# CITY OF MERCER ISLAND

## STAFF REPORT

### SHORELINE SUBSTANTIAL DEVELOPMENT PERMIT

<b>Project No.:</b>	SHL23-026
<b>Description:</b>	A request for a Shoreline Substantial Development Permit with SEPA Review for the removal of a 35 square foot wooden dock and 25 linear feet of concrete bulkhead, construction of a new 650.75 square foot joint-use dock, and installation of two boatlifts.
<b>Applicant / Owner:</b>	Mark Kushino (Waterfront Construction) / Melanie Pritt (6027 32 <sup>nd</sup> St, LLC)
<b>Site Address:</b>	6025 & 6027 SE 32 <sup>nd</sup> St, Mercer Island, WA 98040; Identified by King County Assessor tax parcel numbers 370890-0042 & 370890-0040.
<b>Zoning District:</b>	Single Family Residential (R-15)
<b>Staff Contact:</b>	Molly McGuire, Planner
<b>Exhibits:</b>	<ol style="list-style-type: none"><li>1. Development Application, received by the City of Mercer Island on April 25, 2023</li><li>2. Revised Development Plan Set, dated August 29, 2022 and received September 5, 2023</li><li>3. Project Narrative, received May 25, 2023</li><li>4. SEPA Checklist, received April 25, 2023</li><li>5. Ecological No Net Loss Assessment Report prepared by Northwest Environmental Consu

SHEET: 4 OF 10 NEAR/AT: LAKE WASHINGTON

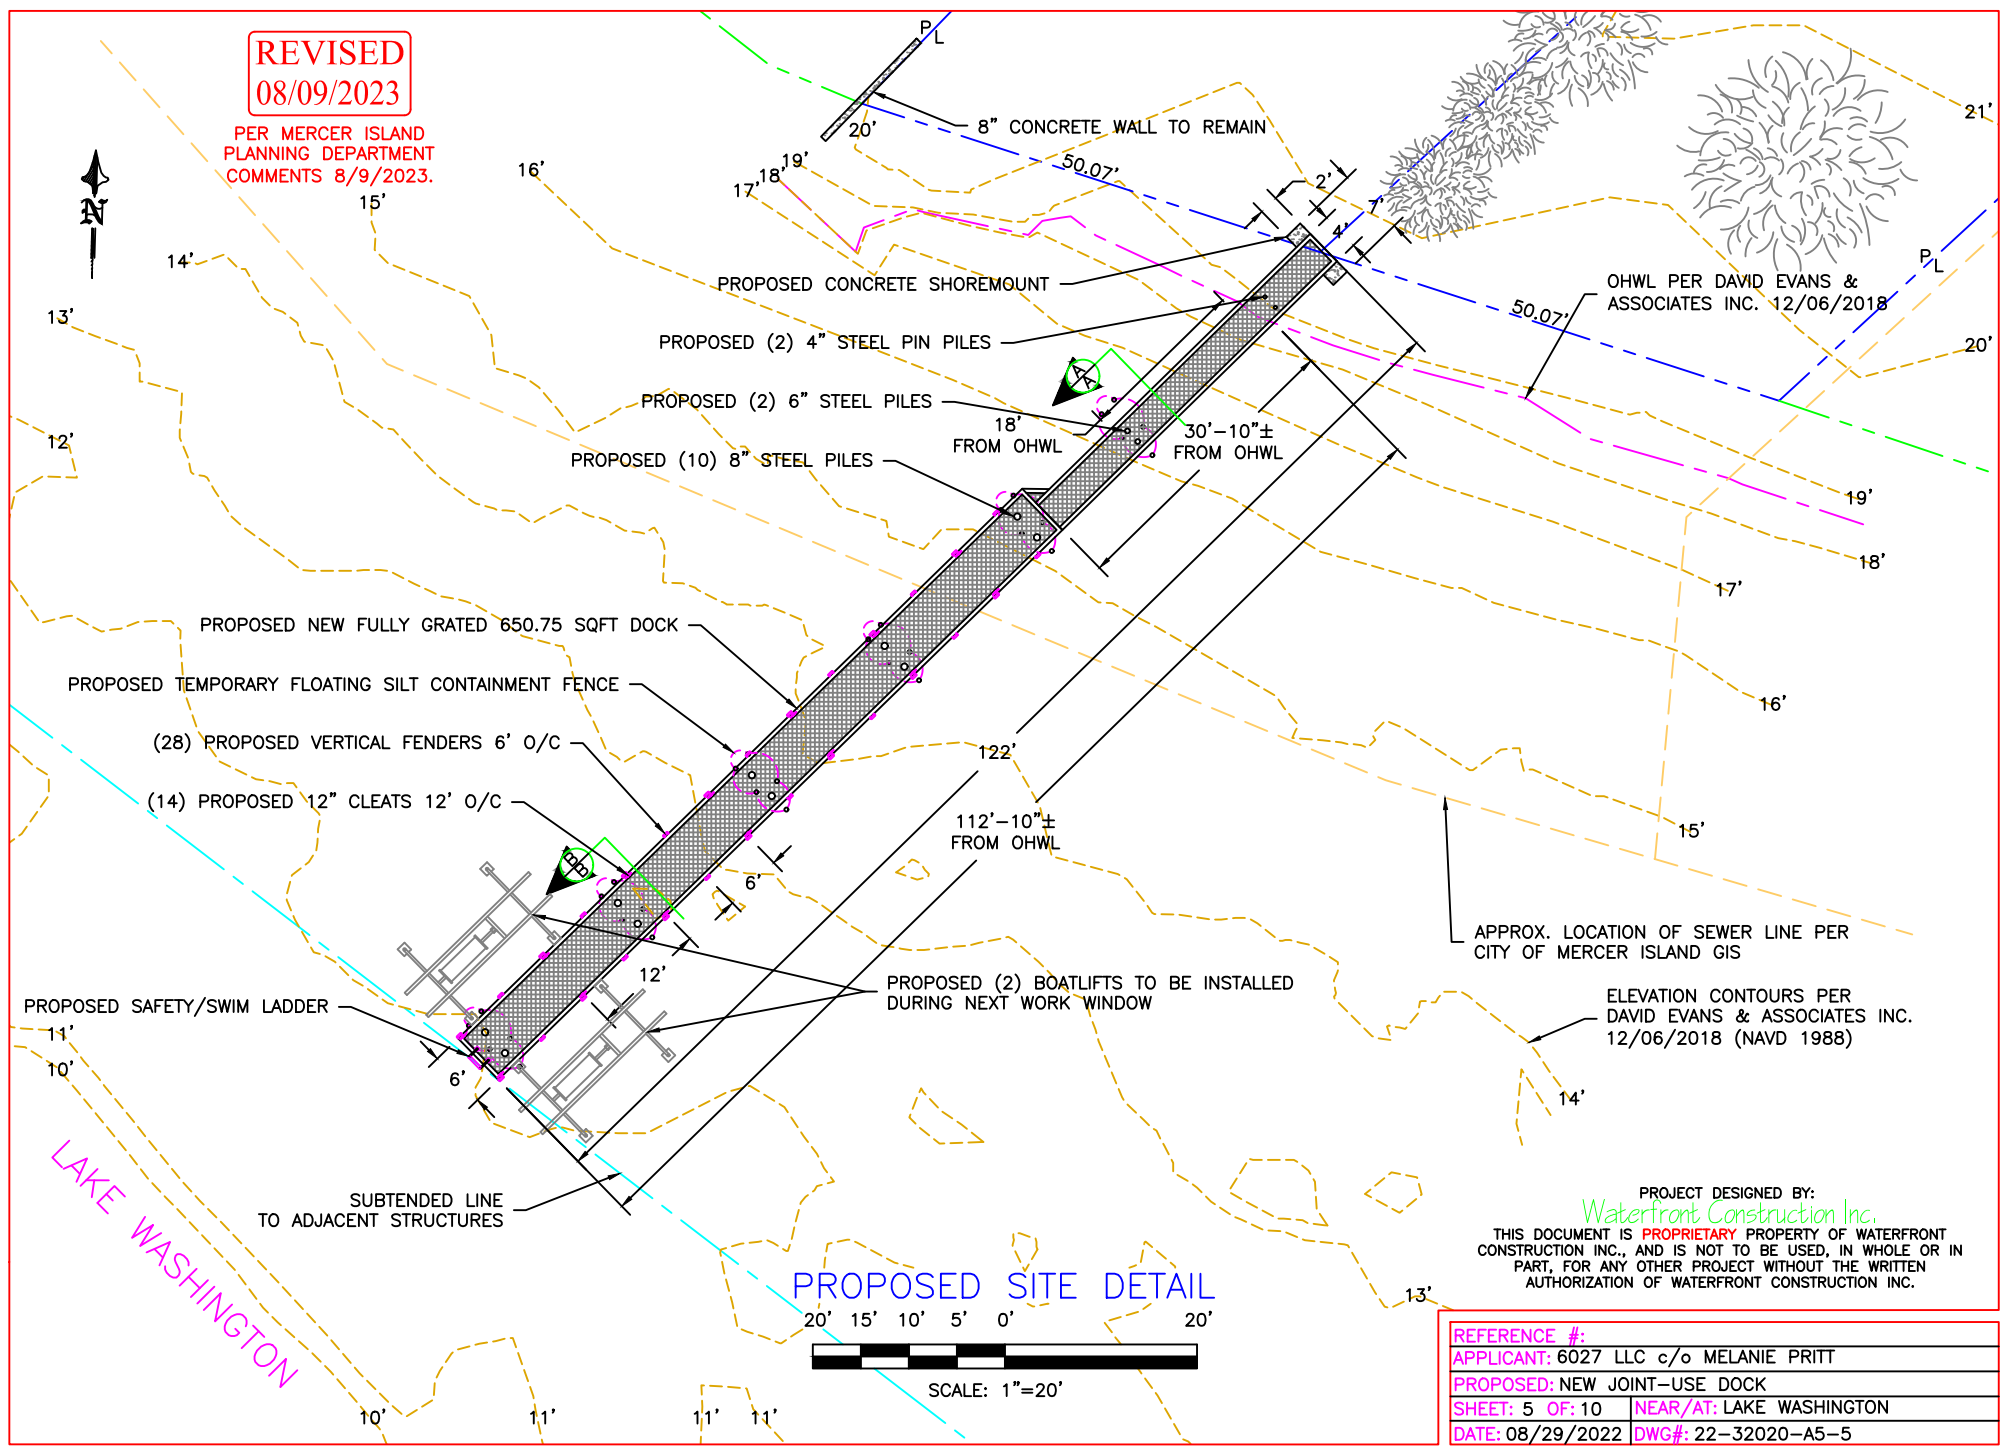
**Staff Analysis:** The proposed moorage facility would be built within 10 feet from the lateral line, subject to the agreement between adjoining property owners (**Exhibit 2, Sheet 5; Exhibit 7**); therefore, this requirement is met.

**Staff Analysis:** The proposed moorage facility extends approximately 112 feet 10 inches waterward from the OHWM. The water depth at the end of the dock is 6 feet 8 inches (**Exhibit 2, Sheet 5**); therefore, this requirement is met.

**Staff Analysis:** The width of the proposed moorage facility within 30 feet waterward from the OHWM is 4 feet (**Exhibit 2, Sheet 5**); therefore, this requirement is met.

**Staff Analysis:** The width of the proposed moorage facility more than 30 feet waterward from the OHWM is 6 feet (**Exhibit 2, Sheet 5**); therefore, this requirement is met.

**Staff Analysis:** The combined water frontage of the two adjoining single-family lots is 100.14 feet (**Exhibit 2, Sheet 5**); therefore, this requirement is met.

**Staff Analysis:** The proposed development would be 4 feet wide within 30 feet waterward from the OHWM and 6 feet wide greater than 30 feet waterward from the OHWM (**Exhibit 2, Sheet 5**); therefore, this requirement is met.
